Reviewed for Code Compliance
Inspections Division
Approved with Conditions

Owner - Ronald ~~Dotter~~ Dorler, Sr. - Trustee
Applicant: Jesse Braley (Pete's Construction)
Address: 7 Morningstar Lane
Lot 1, Morningstar Lane

Date: 10/8/14
C-B-L: 385-C-01
permit # 2014-05

CHECK-LIST AGAINST ZONING ORDINANCE

**Front Elevation**

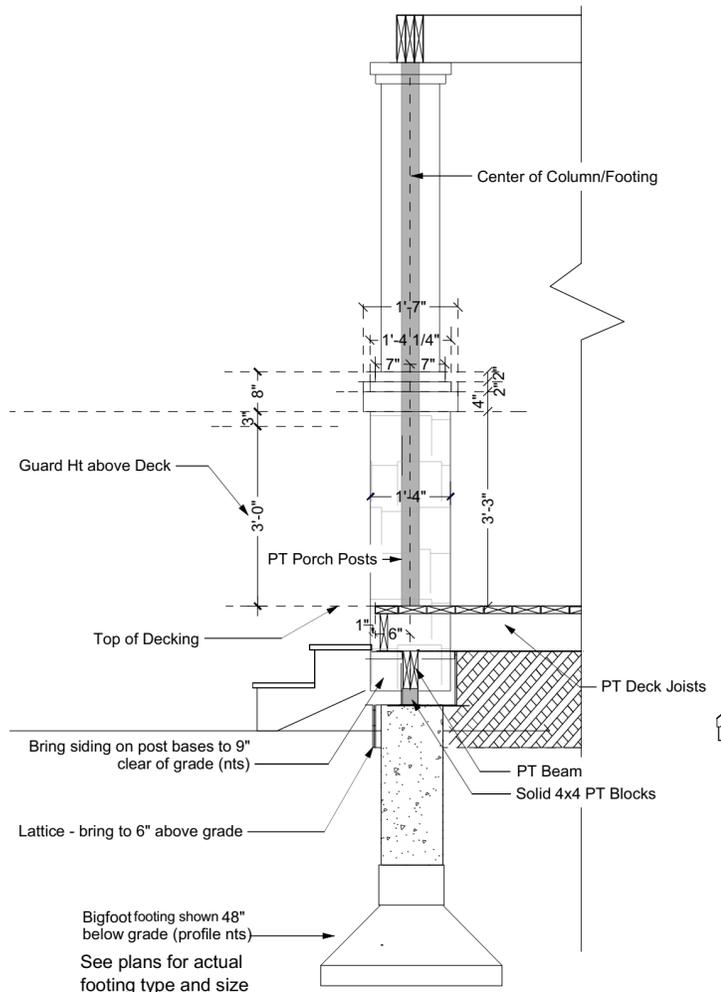
Height - 35' max. - 25' 4" shawl bridge from grade - OK

### SITE PLAN

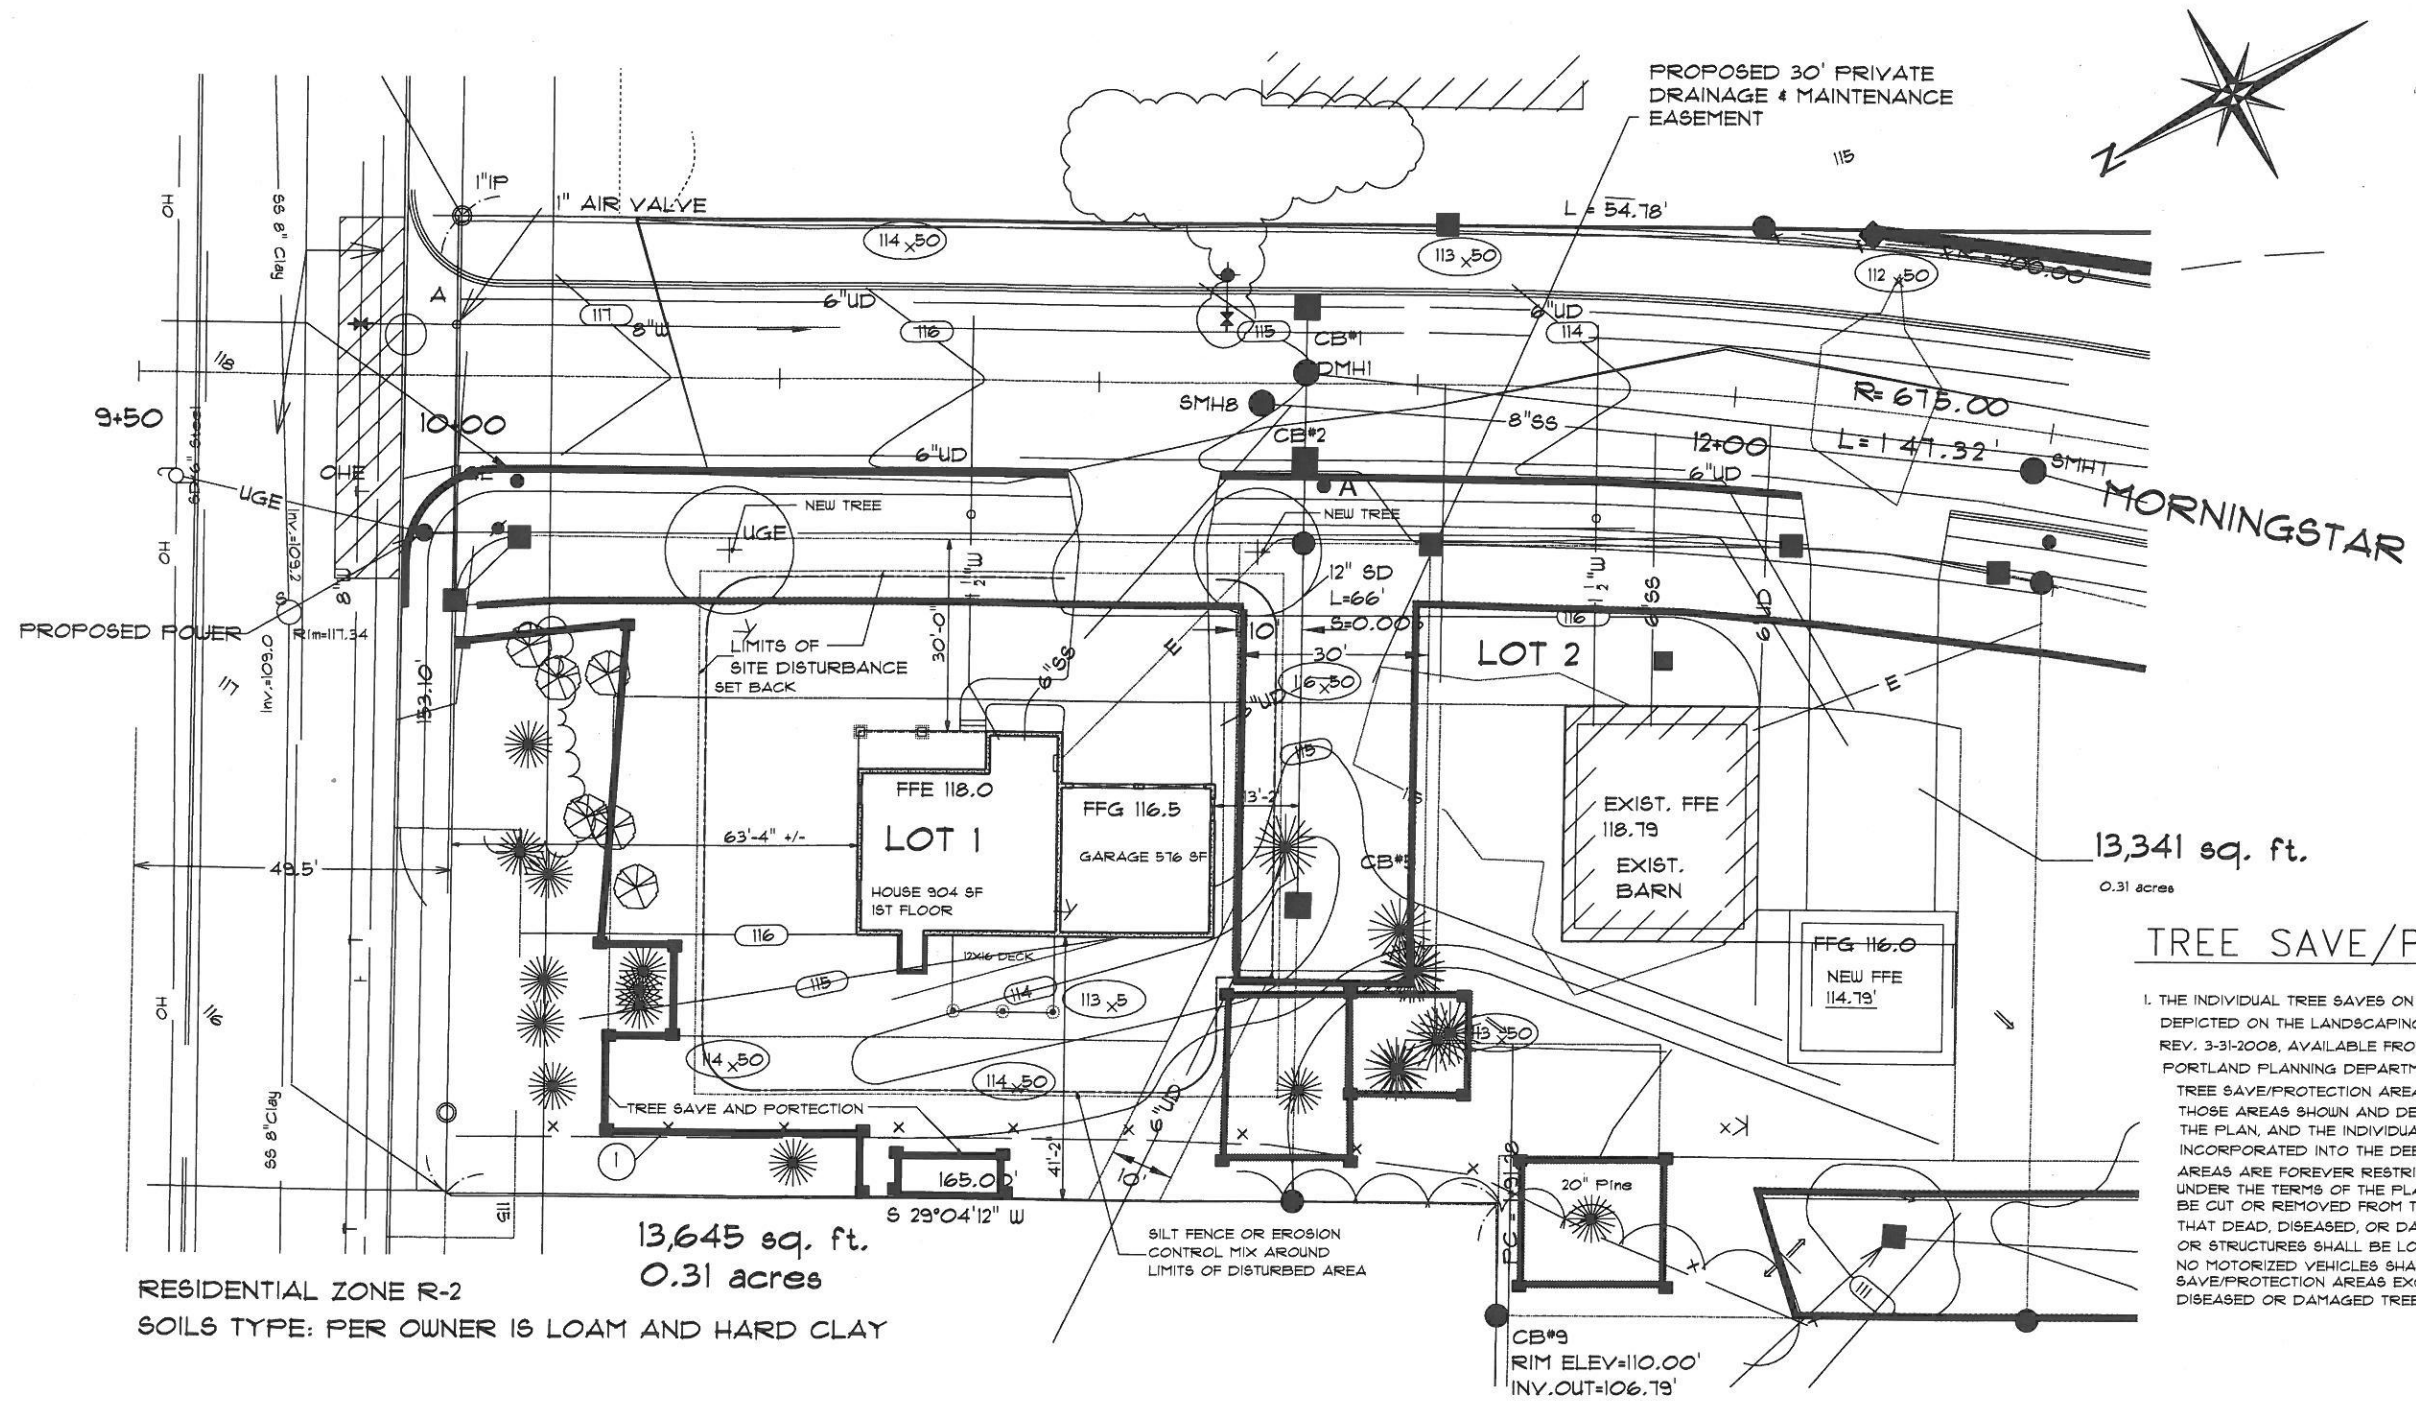
Lot Street Frontage - 50' min. - 127.49' given on Morning Star (OK)

Front Yard - ~~25'~~ 28' min. 28' scaled to front of lot (OK)

Rear Yard - 25' min. - 29.6 to rear of deck (OK)

Side Yard - two stripes - 14' min - 13.43 scaled - can be reduced to 12' if add both sides (OK)

side yard, side street - 20' min - 61.48' scaled (OK)

Lot Area - 10,000 sq ft min, - 13,645 sq ft (OK)

Lot Coverage Impervious Surface - 20% = 2729 sq ft

garage	24'x24'	=	576
house	32'x26'	=	832
bumpout	12'x6'	=	72
front porch	6'x20'	=	120
deck	10'x12'	=	120
steps	3'x4.5'	=	13.5
		1739.5 sq ft	
		1805.5 sq ft	OK

~~1739.5 sq ft~~
1805.5 sq ft OK
